Application No: Y/84/21/HH
Site Address: 5 Hobbs Court, The Potting Barn Bilsham Road Yapton BN18 0JY
Description of works: Installation of 1.8m timber fence and gate and infill of existing dummy door and panelling under window

Thank you for your internet representation made on 3rd July 2021 which has been recorded as an objection with the comments as follows:

Potting Barn. Photos

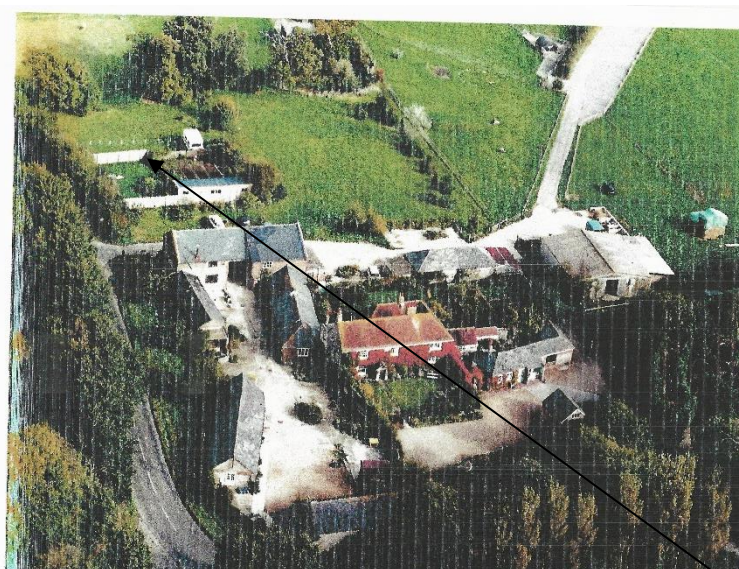
There is one small but very visible section of the applicant's fence that I've only just been shown on the aerial plan that that I am not happy with. This section abuts my own existing fence line on South elevation of The Potting Barn, but will be of a different construction to mine and will be misaligned. As a result it will look very odd. The owner has refused to discuss options with me to improve the look of it. I would prefer it if at least the construction of this small section could match the existing fence design.
